From: Bruce Taunton <Bruce.Taunton@arun.gov.uk>
Sent: 17 December 2019 12:37
To: Planning.Responses <Planning.Responses@arun.gov.uk>
Subject: RE: Planning Consultation on: F/22/19/PL

APPLICATION NO: F/22/19/PL

Site Address: Unit C5, C8, C9 Ford Airfield Industrial Estate Rollaston Park Ford
BN18 0HY

Description of Works: Over roofing of industrial units

Proposed Elevations, Sections & Roof

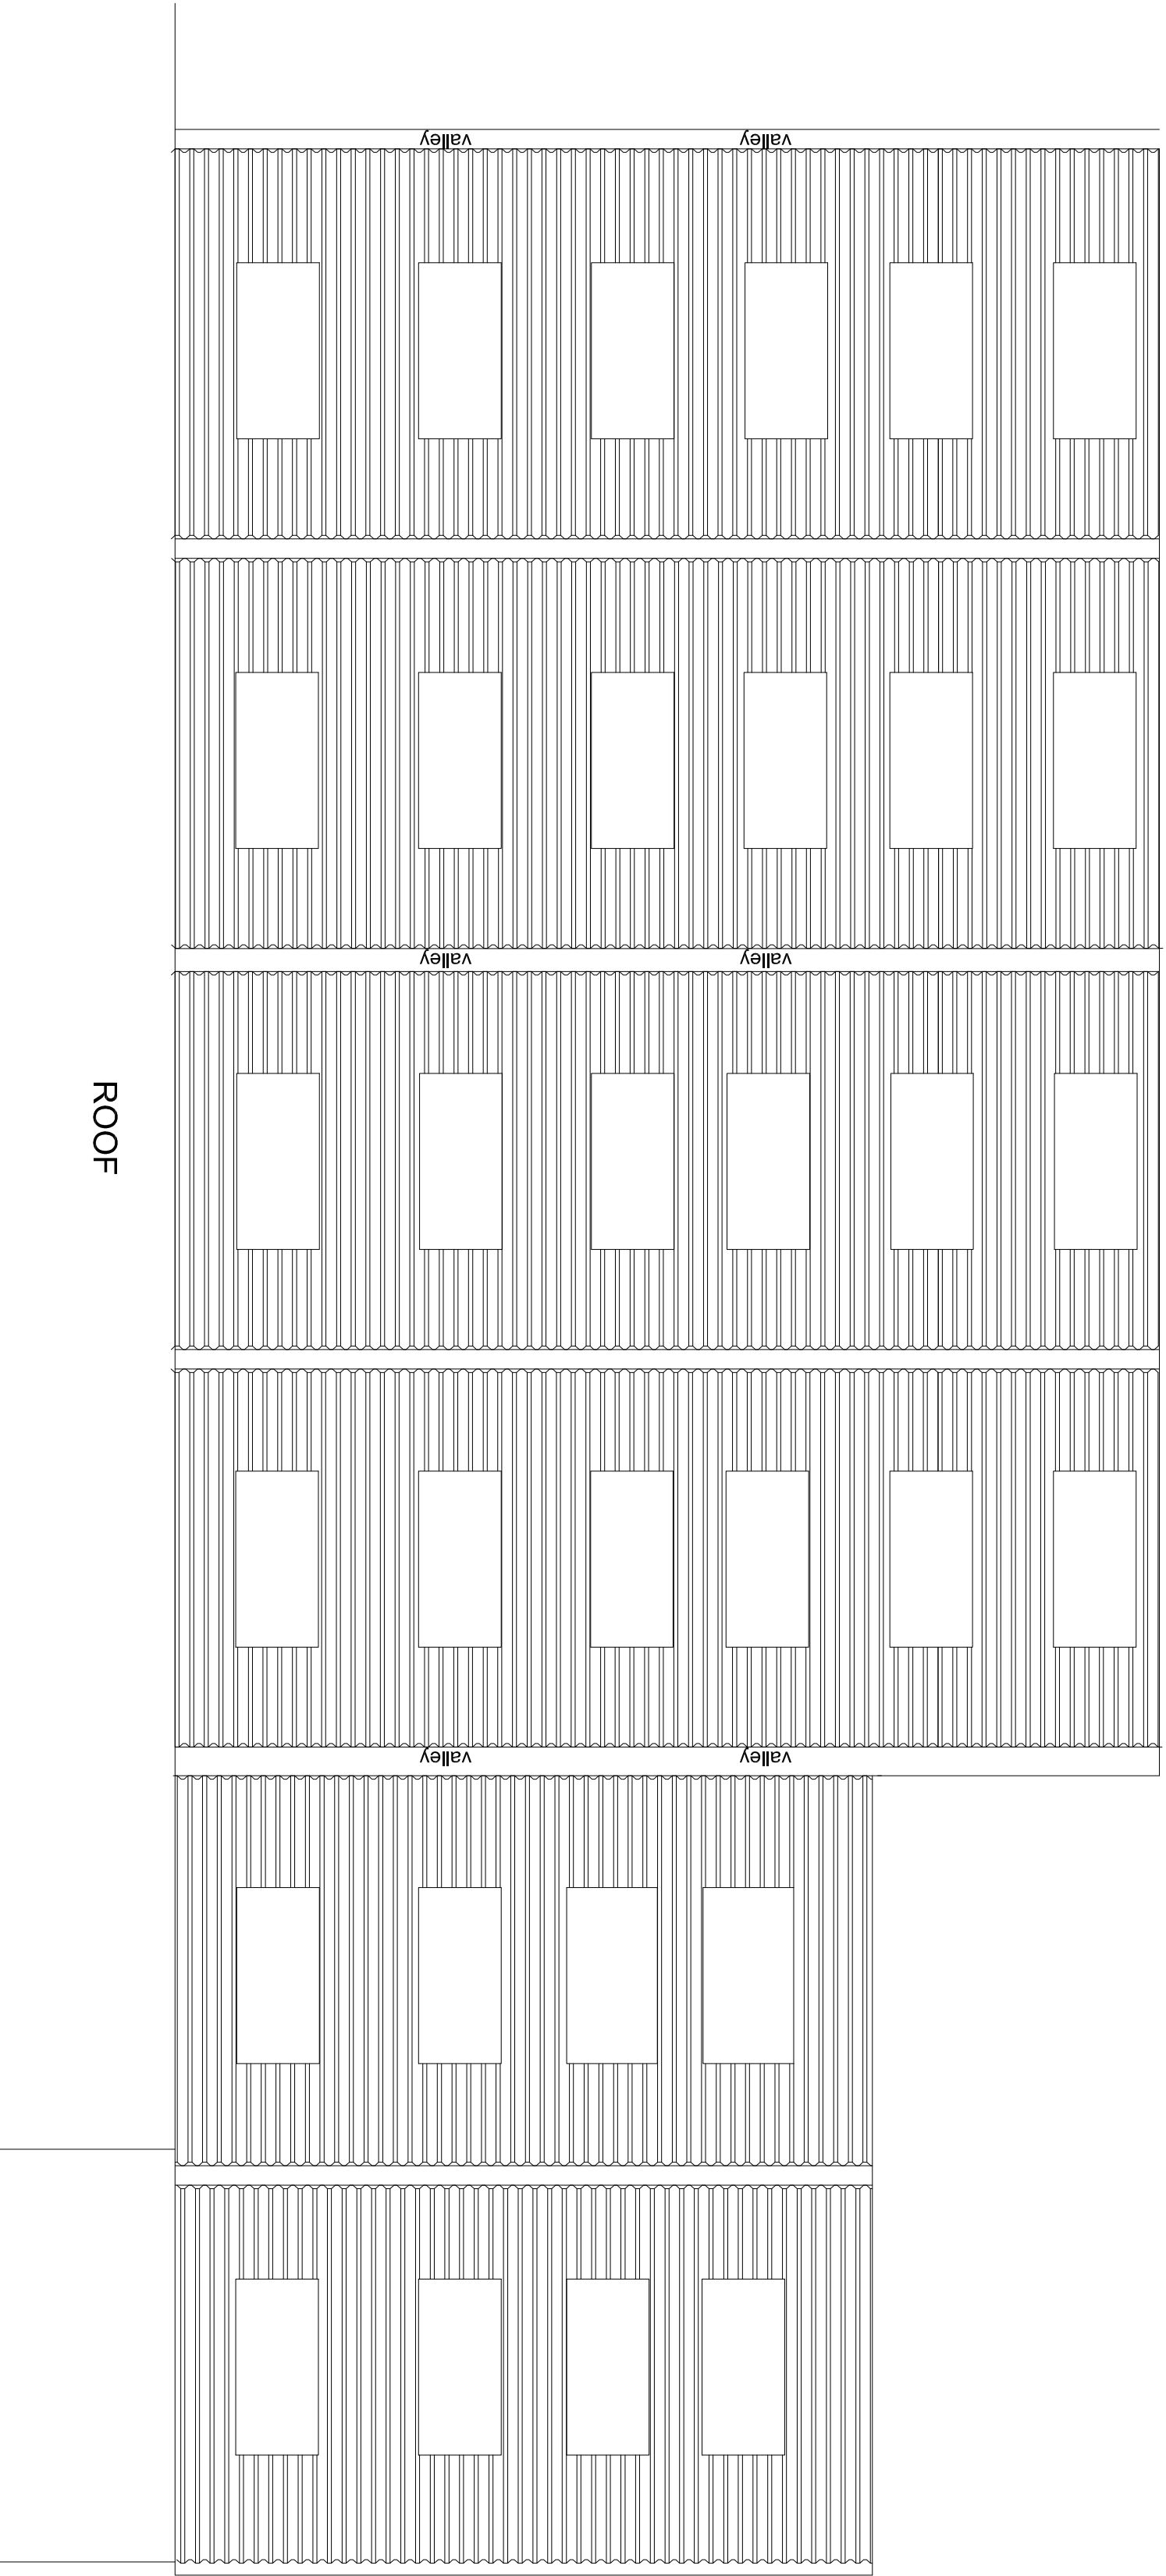
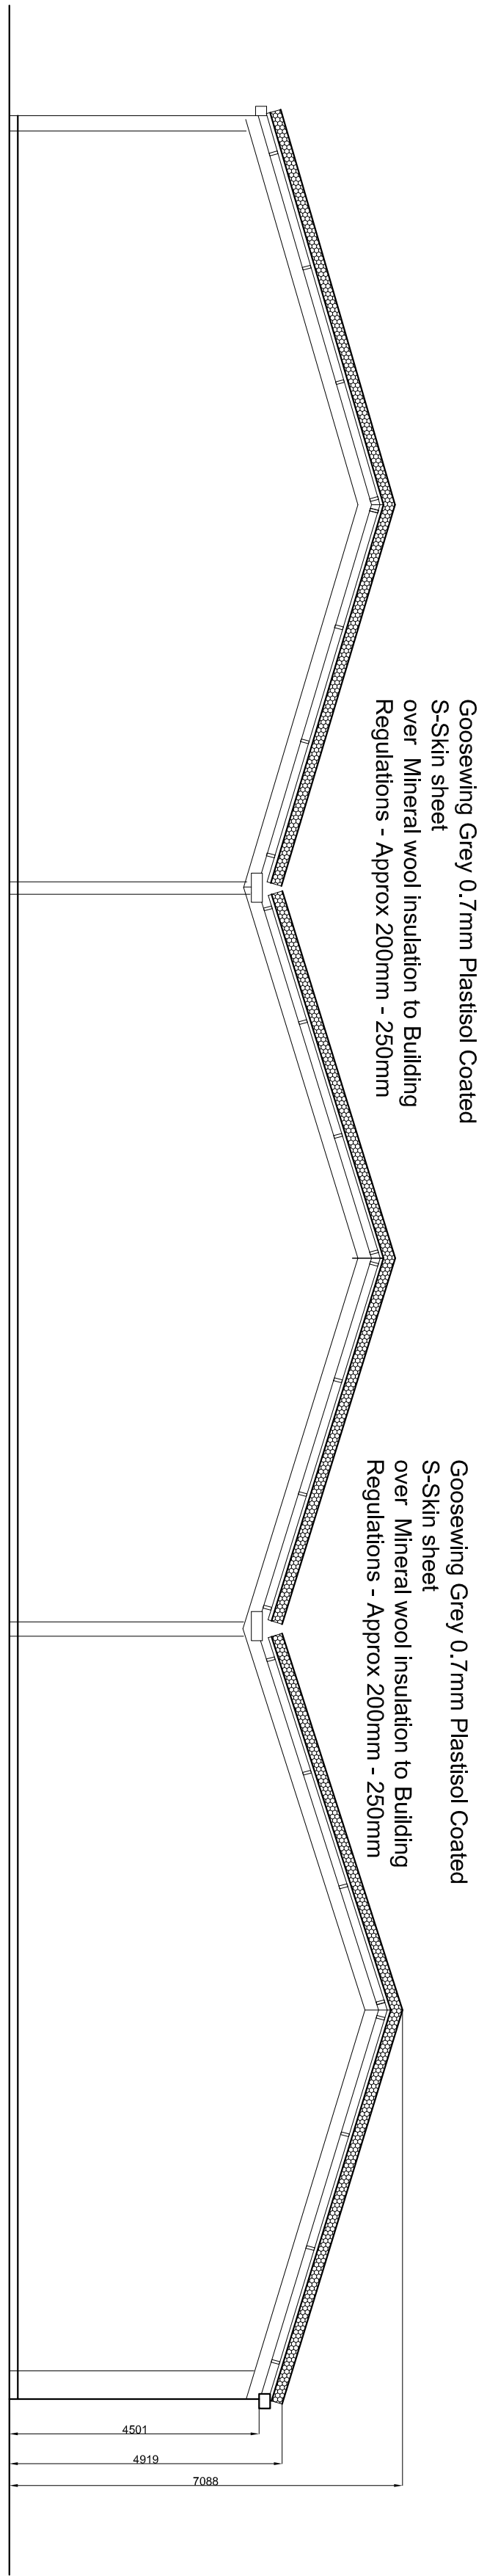
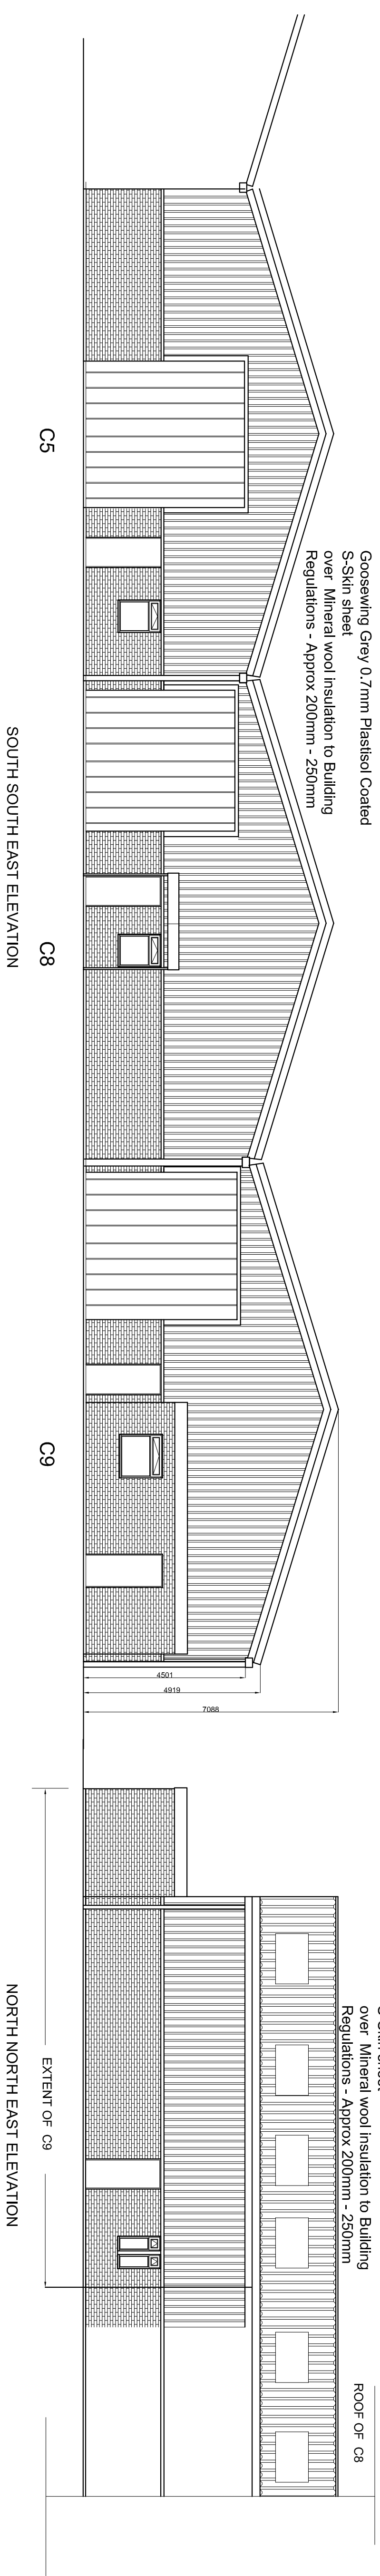
Over boarding of the roof will likely see an increase in load of greater than 15% that will require Building Regulations approval. The existing frame and purlins will need to be assessed for adequacy for both vertical loading and wind loading.
